Key Sites and Industry Assessments
Department of Planning, Industry & Environment
GPO Box 39
SYDNEY NSW 2001

**New Request for Advice – ESR Horsley Logistics Park (SSD-10436) (Fairfield City)
Environmental Impact Assessment**

TAB A – TfNSW Comments – SSD 10434 EIS ESR Horsley Logistics Park

Figure 3: Road Hierarchy

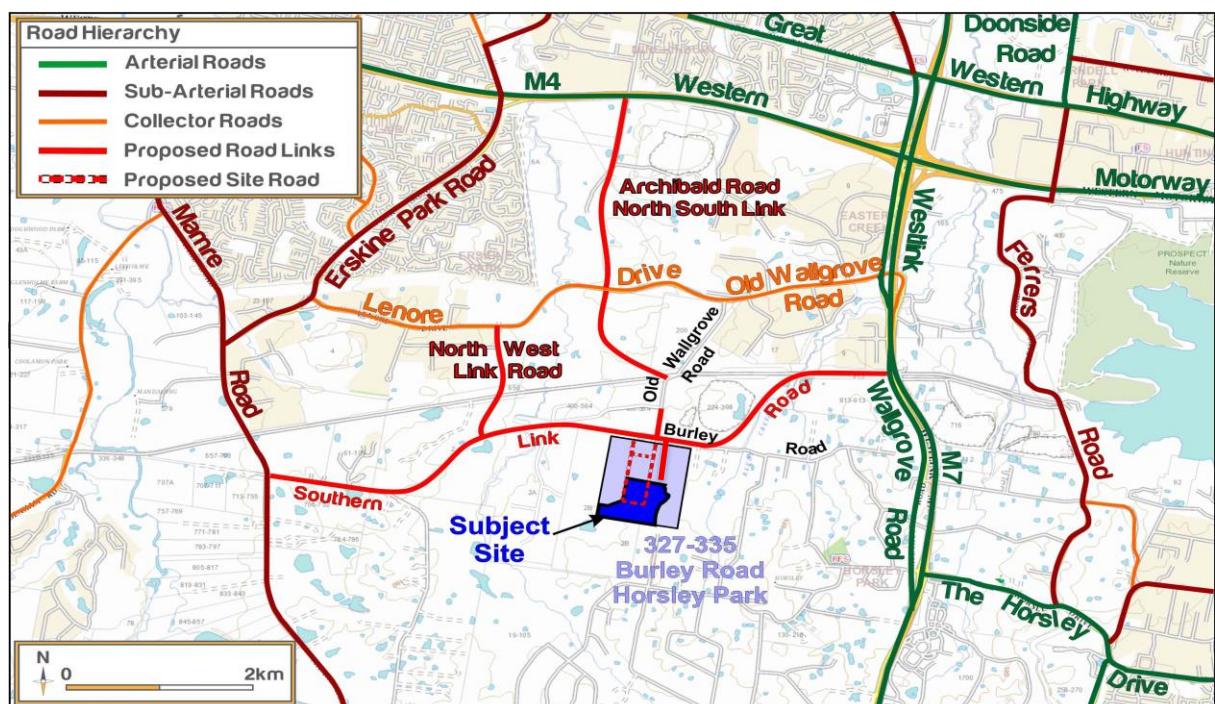
In the TA, Figure 4 - Road Hierarchy – there is no explanation of how the classification provided in this functional hierarchy was determined.

It is requested that the TA be revised to provide the reference documentation from which the functional classification of proposed road links was derived.

Figure 4: RAV Map

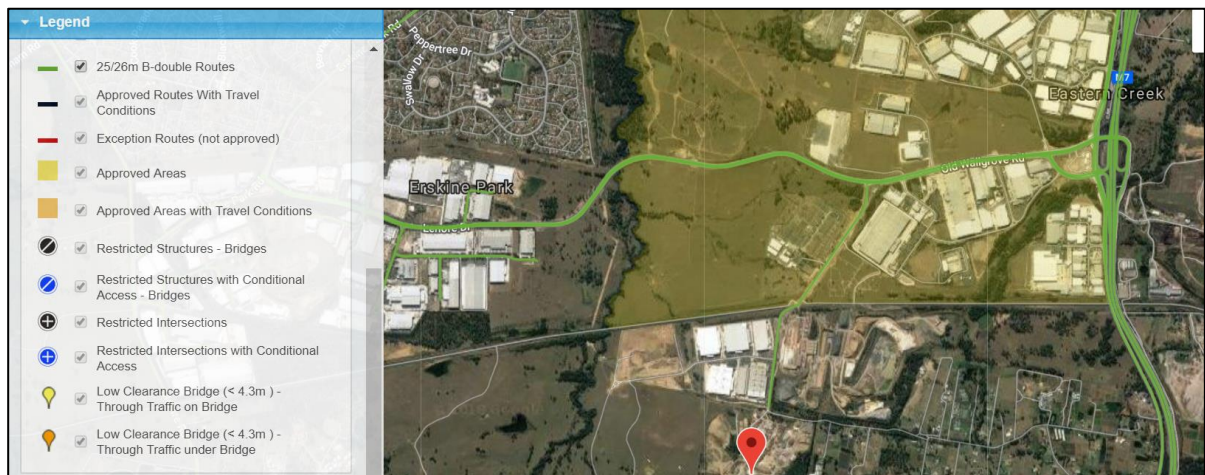
Figure 5: RAV Map - Rather than a prescriptive heavy vehicle combination it would be better generalise in terms of PBS vehicle access. e.g Millner Avenue is an approved PBS 2A route that does not appear on this map. This precinct should accommodate at least PBS level 2B vehicles.

Figure 8: Stage 3 Indicative Road and Intersection Arrangements

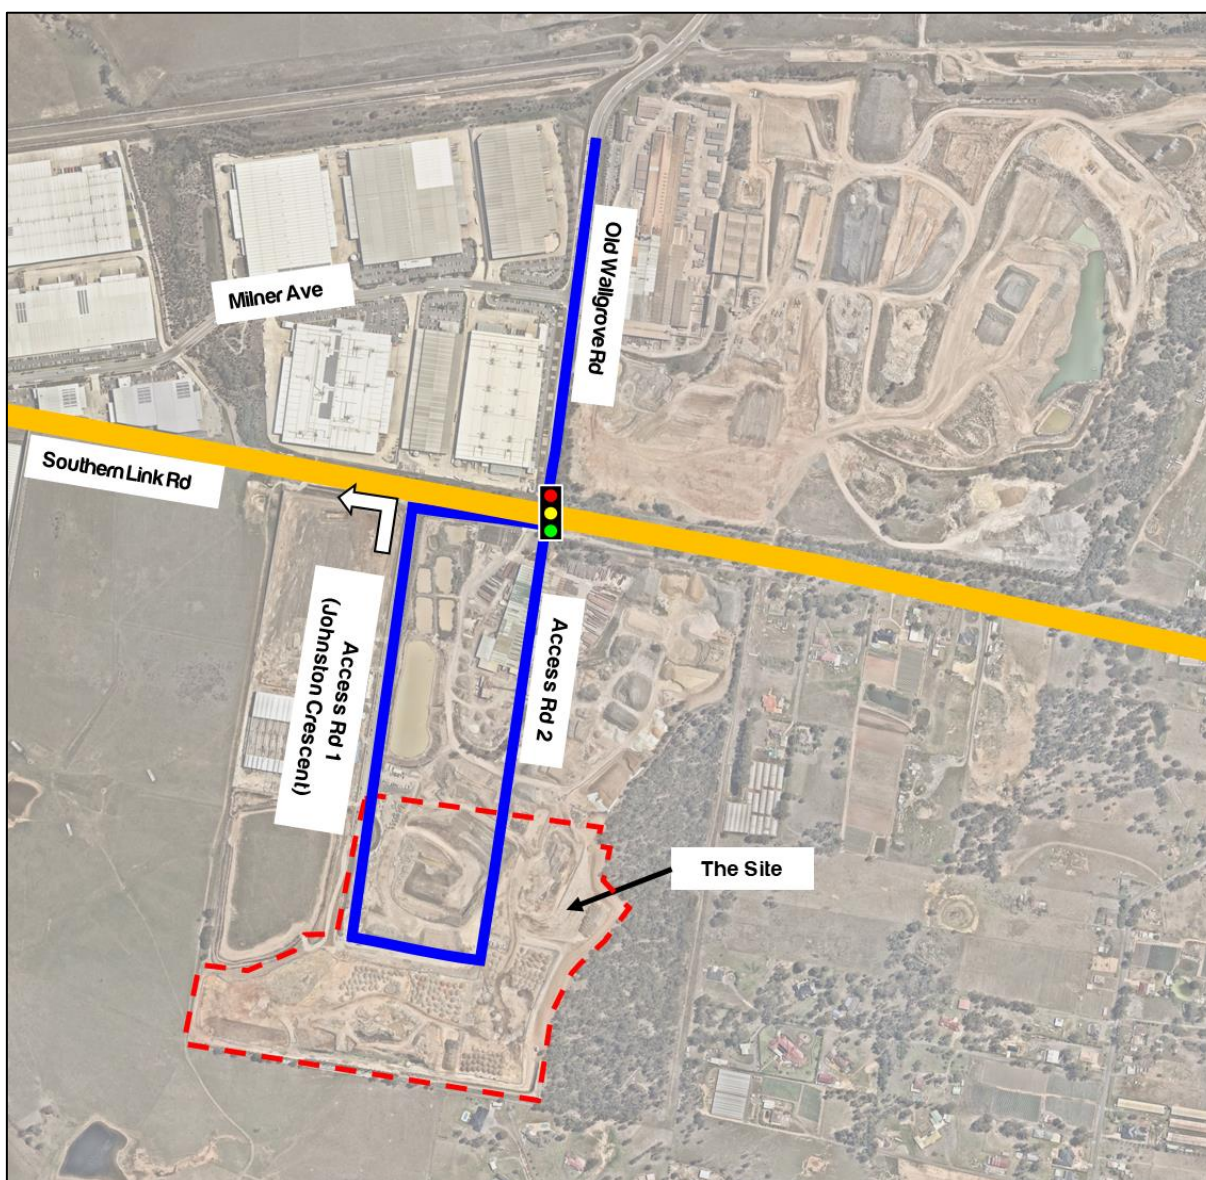
In the TA, Section 6.2 Proposed Works – Figure 10: Stage 3 Indicative Rd and Intersection Arrangements shows left-in, left-out only Johnson Crescent/ Burley Road (Southern Link Road).

On 5 December 2019, TfNSW sent a letter to Calibre Consulting referring to Stage 3 Future ultimate Southern Link Road (SLR)/ Johnston Crescent Intersection Interface indicating TfNSW does not support a left-in/out intersection arrangement at Johnston Crescent once the four-leg signalised intersection is developed at Old Wallgrove Road/ Southern Link Road, providing access through the ESR site to service all businesses within the development site.

Once the four-leg signalised intersection is operational at Old Wallgrove Road/ Southern Link Road and all the ESR stages are completed then the acceptable option to TfNSW is left-out only from Johnston Crescent turning onto Southern Link Road.

It is requested that upon completion of all stages of the ESR and the four-leg signalised intersection is operational at Old Wallgrove Road/ Southern Link Road, Johnston Crescent is configured as left out-only onto the Southern Link Road.
